Our ref: DOC21/1094920

Senders ref: SSD-8903-MOD3

Subject: EES comments on Response to Submissions for Modification Application for Stage 1 of Ivanhoe Estate, Macquarie Park - SSD-8903-MOD 3

**ADDITIONAL TREES  
TO BE REMOVED**

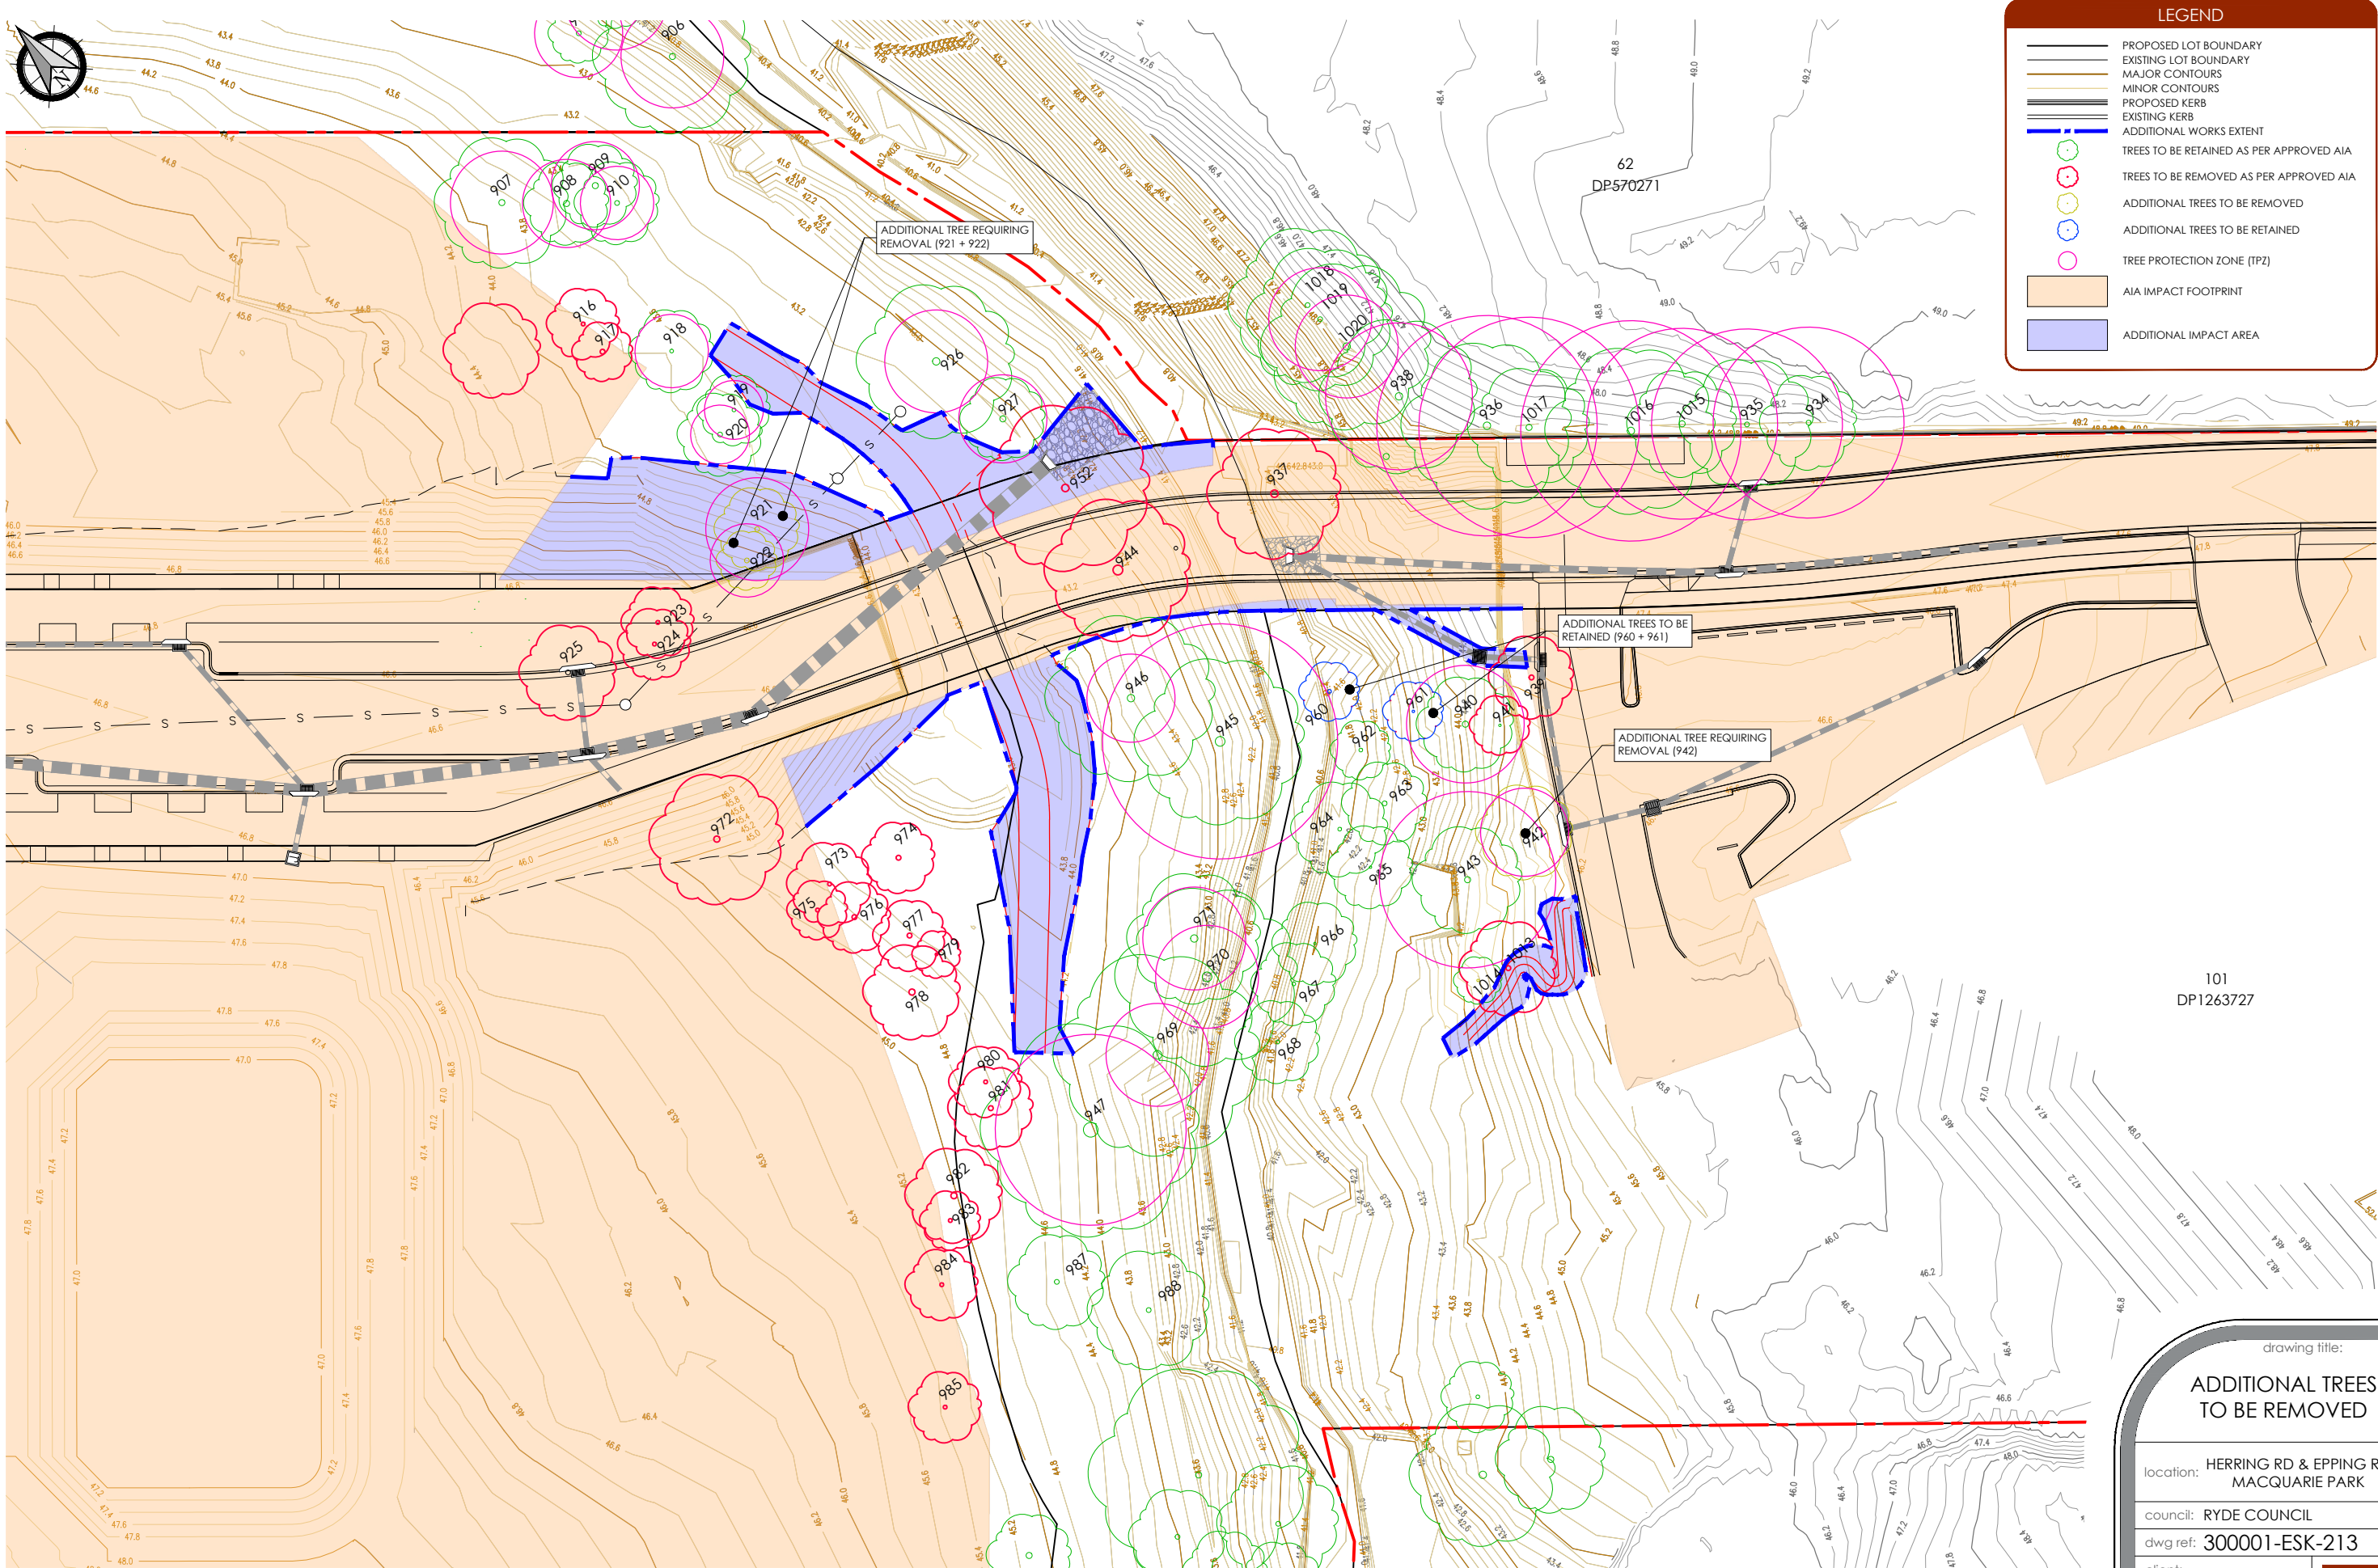
EES queried whether any of the three trees to be removed contain nests, dreys, hollows etc. In response Ethos Urban state the presence of nests, dreys and hollows is addressed as part of the endorsed Biodiversity Management Plan (BMP) under Condition B47 of the Stage 1 consent and the BMP provides processes for the pre-clearance survey of vegetation and the replacement of removed hollows at a rate of 1:4. As the BMP has not been provided to EES as part of the RtS, EES recommends Industry Key Sites ensures this requirement is clear in the existing consent and the BMP to ensure pre-clearing surveys occur for the MOD 3 proposal. If there is any doubt, EES recommends a condition is included for the MOD 3 proposal to provide clarify and to ensure pre-clearance surveys are undertaken by an appropriately qualified ecologist for the MOD 3 proposal, any resident native fauna are appropriately relocated and replacement hollows are provided if required for this proposal.

EES previously advised no details had been provided on the two trees that are now proposed to be retained (trees 960 and 961) such as tree height, diameter at breast height (DBH), retention value and whether they are local native species or exotic. Ethos Urban confirm the trees to be retained are mature *Casuarina cunninghamiana* and the Appended letter by Ecological Australia includes details on the tree species, height and diameter.

EES recommended the MOD 3 proposal reuses native trees that are to be removed including hollows and tree trunks (greater than approximately 25-30cm in diameter and 2-3m in length) and root balls within the riparian corridor or other areas on the Ivanhoe Estate site which are to be

replanted with local native species. The RtS does not specifically address this and EES repeats its recommendation that a condition of consent is included to this effect

EES previously recommended the trees proposed to be removed are replaced at a ratio greater than 1:1 (for trees not covered by a biodiversity offset strategy) and the replacement trees consist of local native provenance species, particularly as the three trees to be removed were initially approved for retention, and no information had been provided on the two trees proposed to now be retained. As noted above, the RtS now provides information on the two trees to be retained. Ethos Urban also state further native vegetation will be planted across the Master Plan site with each progressive stage of the project in accordance with Condition A17 of the Master Plan consent. Ethos Urban also confirm the replacement ratio remains greater than 1:1 across the Master Plan site.

EES recommended a condition of consent is included in relation to this issue but Ethos Urban consider a further condition of consent is not required. If there are likely to be further modification proposals which also require tree removal, EES considers the inclusion of a condition which outlines the tree replacement requirements for each Modification proposal would be useful for clarity.
